From: Anita Gardner
Sent: 28 February 2018 15:55
To: Planning.Responses
Subject: FW: Planning Consultation on: AB/149/17/L

APPLICATION AB/149/17/L

Site Address: 44 Tarrant Street Arundel BN18 9DN

Description of Works: Listed building consent for internal alterations & renovations

Job Title	44 Tarrant Street, Arundel		
Client	Mr & Mrs N Field		
Drawing Name	Plans, Lower and Ground Floors		
Drawing Status	Planning & Building Regulations		
Drawn by	AF	Date	11/17
Checked by		Date	
Drawing Scale	1:50 at A1 1:100 at A3		
Drawing No	Status	Revision	
171164/ 103		B

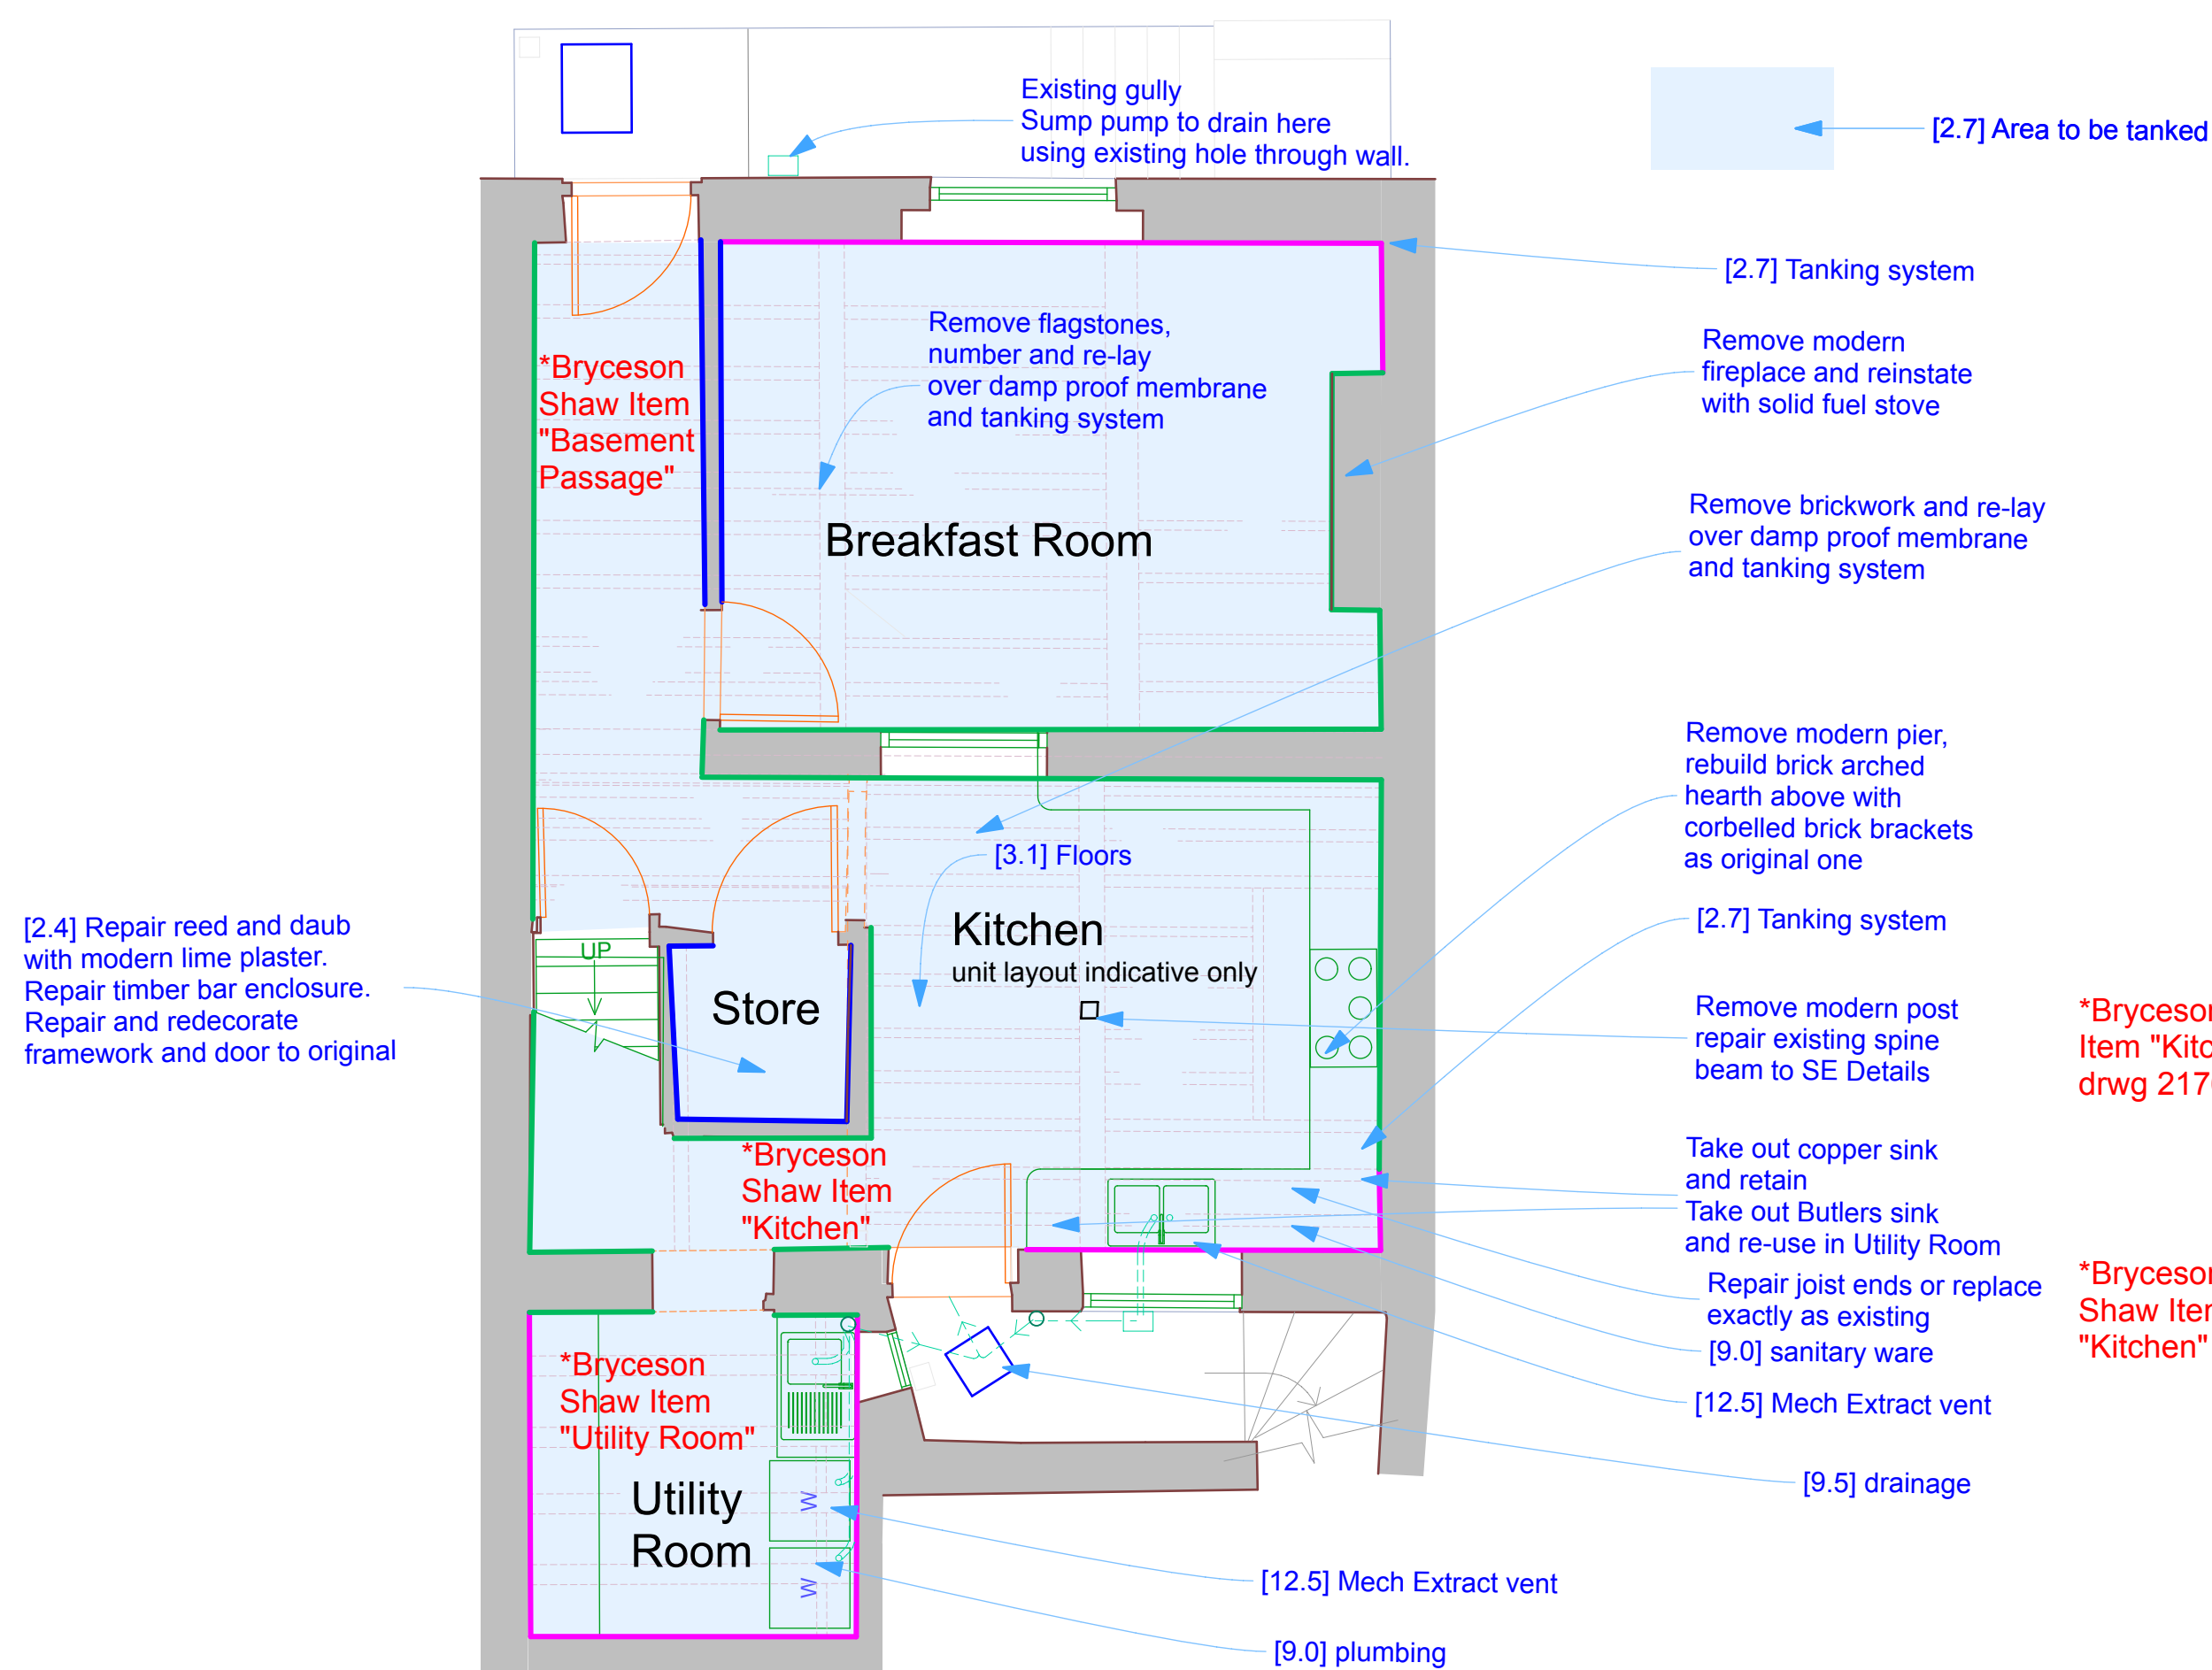
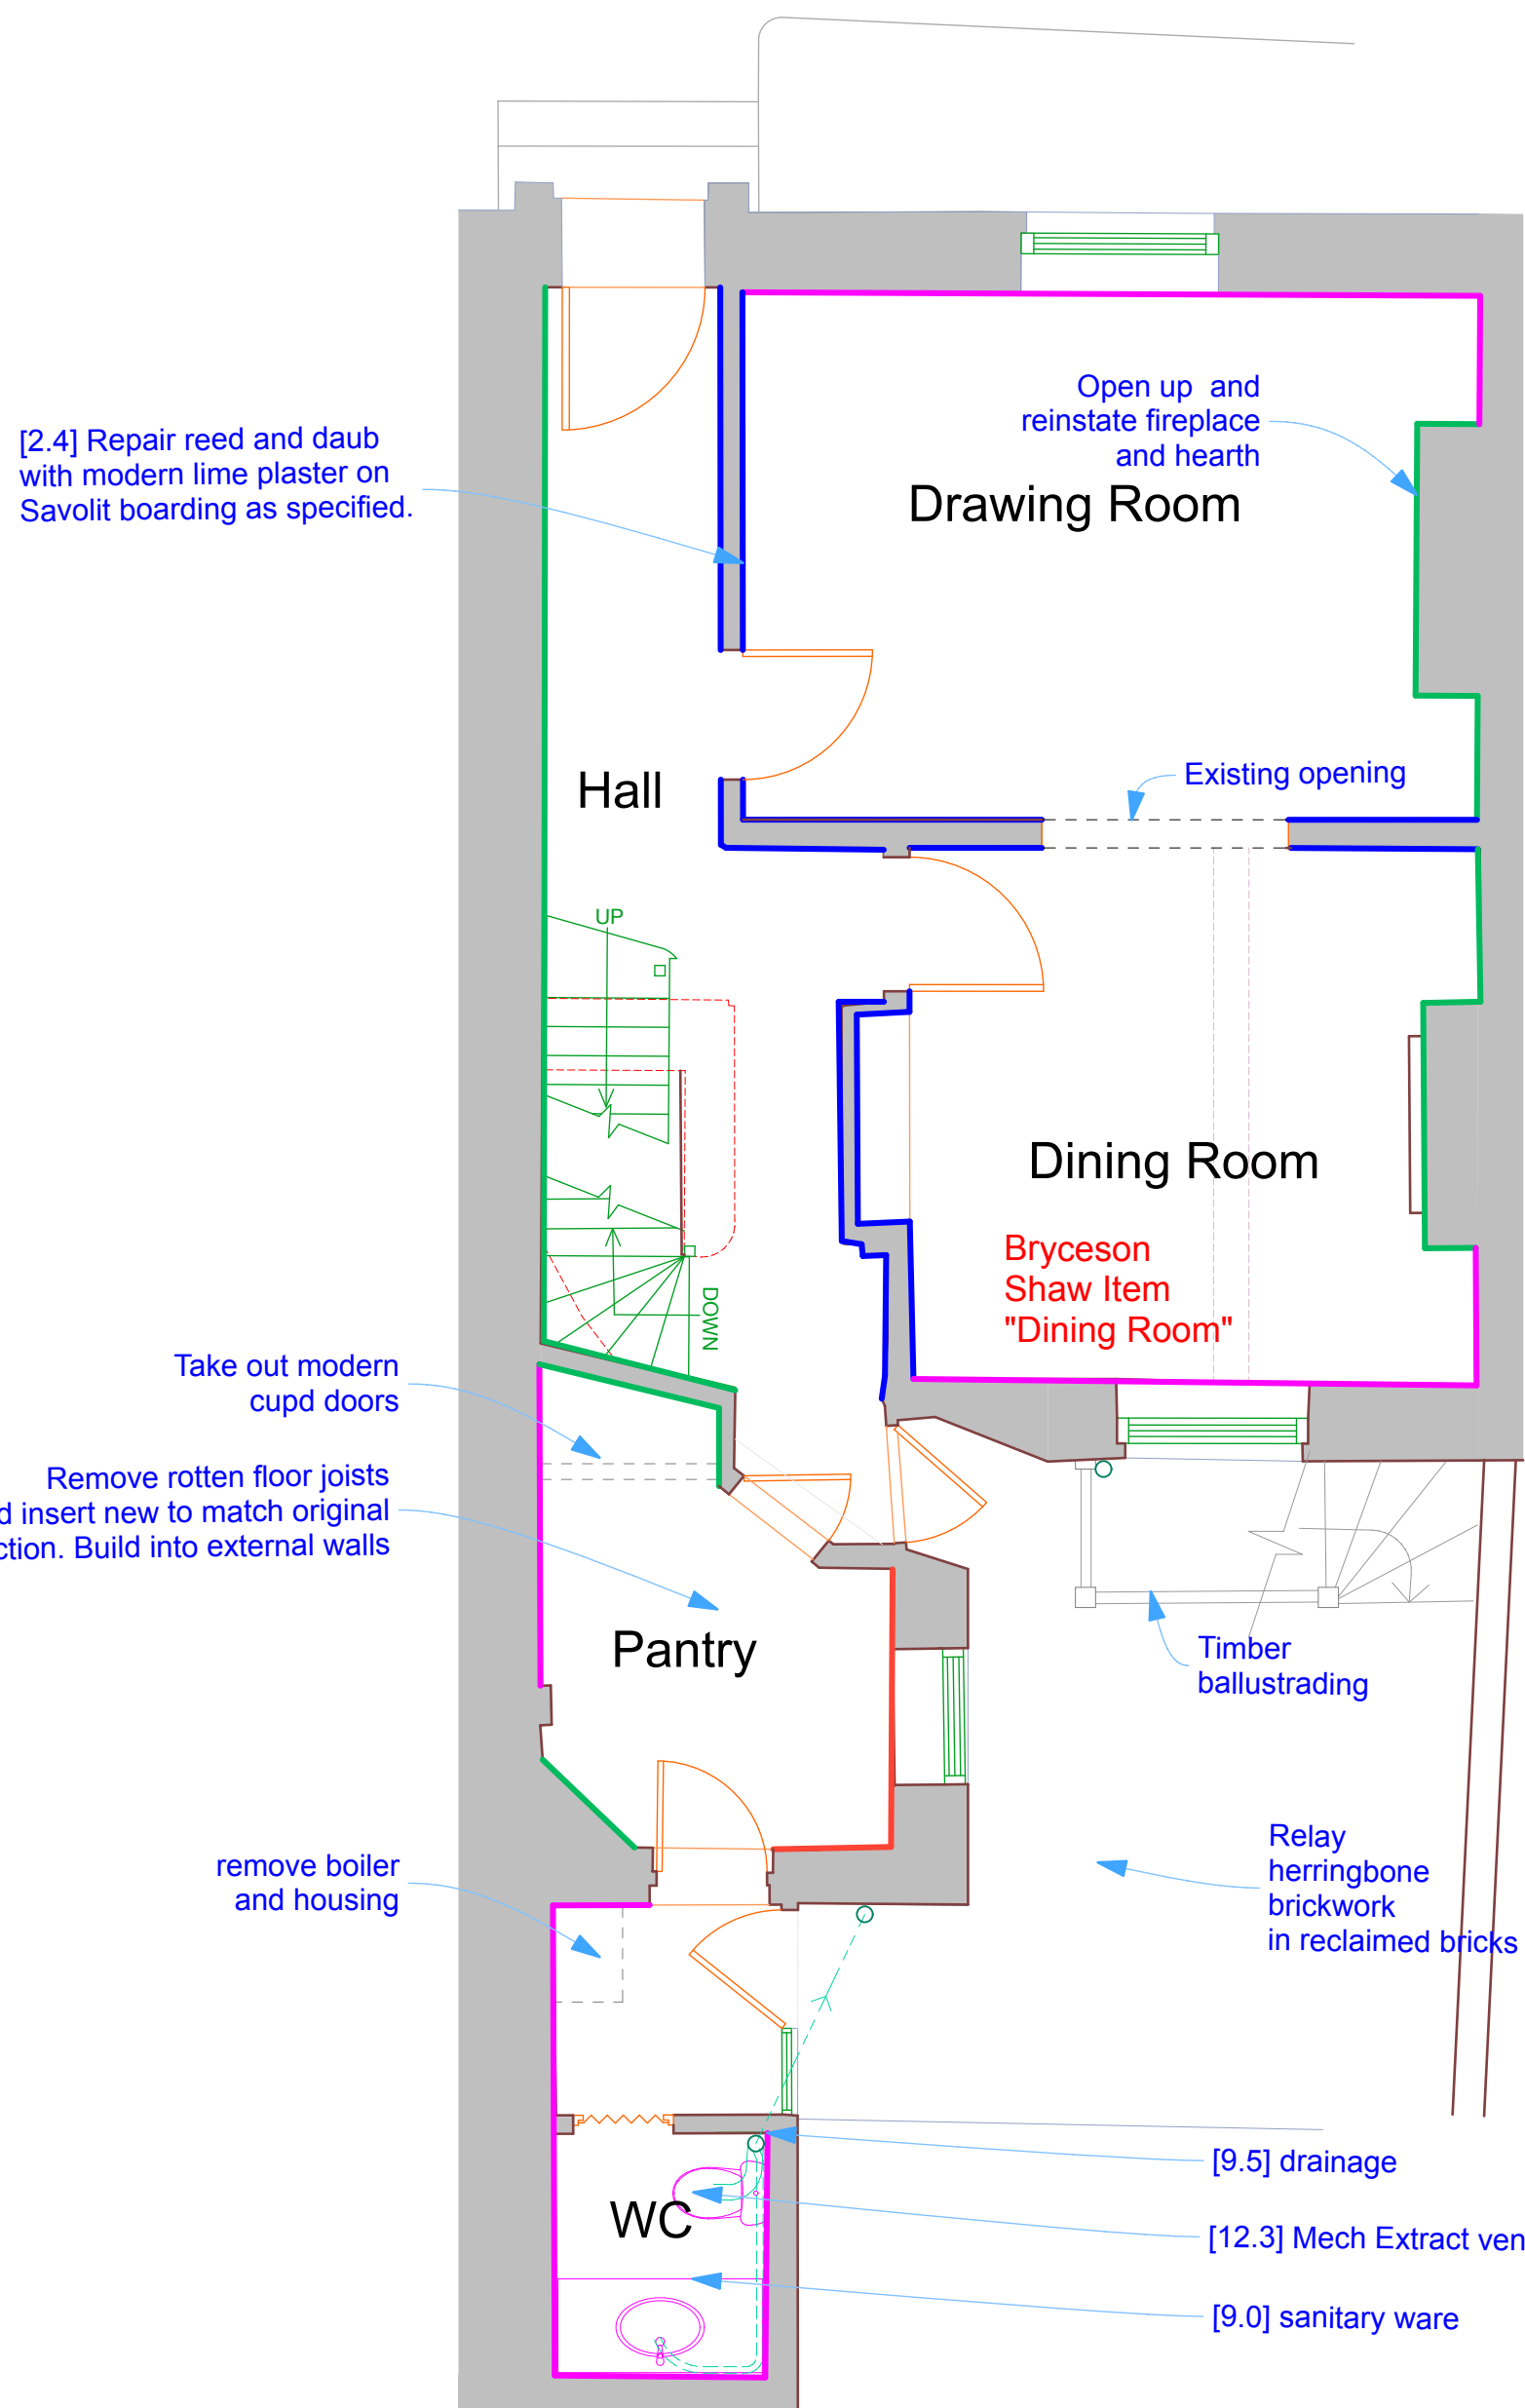
- Existing floor plan. The submitted plans marked 'Planning & Building Regulations', show some dotted lines which I presume to be walls which have been removed. For clarity, a set of plans which show the building before any works had been carried out should be submitted. Such should include features that would appear on plan.

- Submitted Drawings: Works refer to internal works only, while external works appear to have been carried out. It is noted that some reference to 'relay herringbone paving and timber balustrading' is noted on Dwg 17/164/103 Works would appear to exceed this description. Description supplied in 'Description of Works' is incomplete.

- It is unclear as to proposed location of structural drawing 'Proposed Repair' Bryceson Shaw Associates. This detail is not marked on any plans.
- Unclear 'SE Drawing & Report' referred to under 'Kitchen Proposed' – (This is apparently spine beam repair)
- Replacement of structural elements/repairs to not appear to be supported by a full and thorough structural report. This includes rear elevation, spine wall to lower ground floor, joists to pantry. It is noted that two 'Statements of Support have been provided by the Agent.
- 'Bedroom 4' photo shows apparently failing wall plate. This should be replaced to engineers specification, and ceiling/wall made good with traditional lath/plaster (the photo supplied seems
